Longfield Solar Farm

Statement of Common Ground – National Highways

PINS Reference: EN010118

Document Reference: EN010118/EX/8.4(B)

Appendix B – Surrounding Highway Network

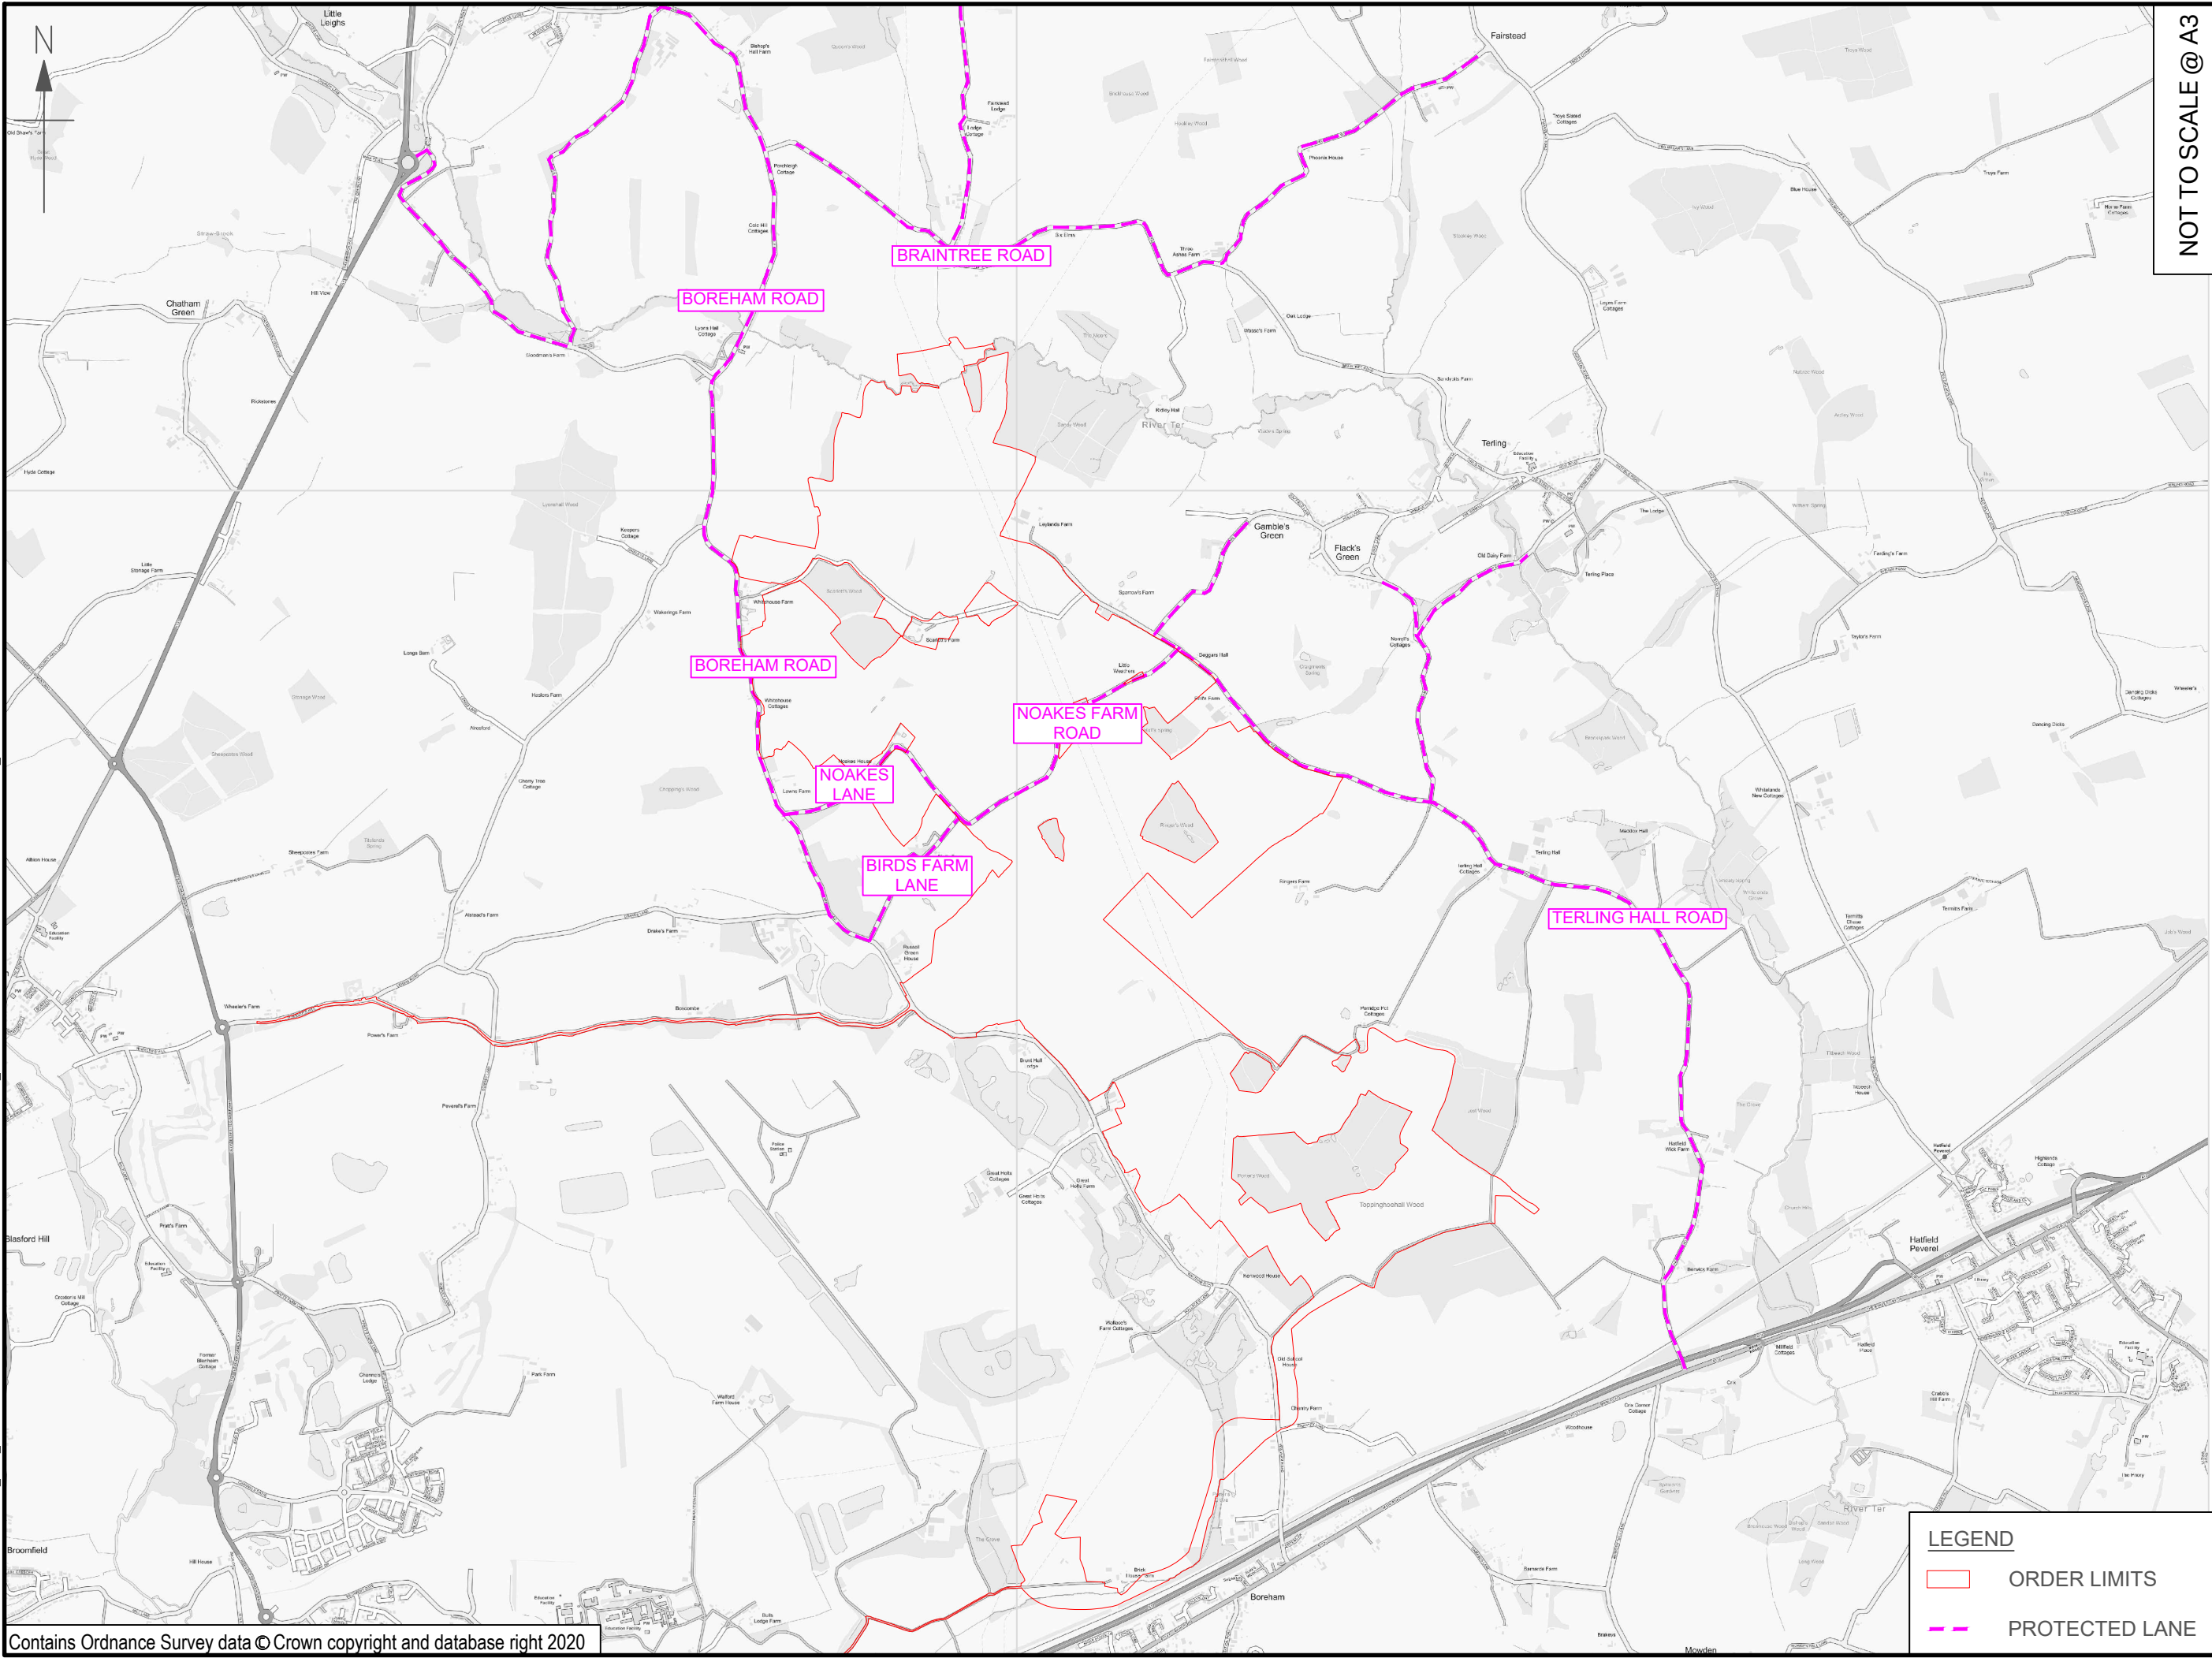
4.9	<p>Private Road to/ from Bulls Lodge Substation</p>	<p>As mentioned in the Framework CTMP and shown in 'Appendix B – Surrounding Highway Network', Longfield Solar Farm proposes to utilise a private road via Boreham Interchange/RDR for Bulls Lodge Substation compound and construction. The A12 Scheme also proposes to utilise this private road's access for construction purposes including a haul route, compound and lay down area and soil storage. Effort is being made between both parties to ensure the private road is shared between both schemes during construction, working together to agree and establish this in the SoCG. However, there remains uncertainty with regards to the status of the private road. The private road is currently owned by Countryside Zest (Beaulieu Park) LLP and is expected to become an adopted highway upon completion of the Beaulieu Park development, the timing of which is unknown. Prior to the adoption of the highway, it is still to be agreed which entity will act the Principal Contractor, therefore highway rules to be complied with remain uncertain (i.e. speed limits, access controls). National Highways and</p>	<p>It is acknowledged that there will be a requirement for both schemes to share the private road to/ from Bulls Lodge Substation during construction. Measures to manage construction vehicles along the private road are set out within the Longfield Solar Farm Framework CTMP [EN010118/APP/6.2(A)]. Measures to manage construction vehicles along the private road will also be set out within the A12 Scheme Outline CTMP. Access between the RDR, private road and the A12 will be retained for both schemes, including with respect to the order limits for the proposed haul route, compound and lay down area and soil storage for the A12 to A120 Widening Scheme. Further discussions to be held once the Principal Contractor has been determined.</p>	Agreed
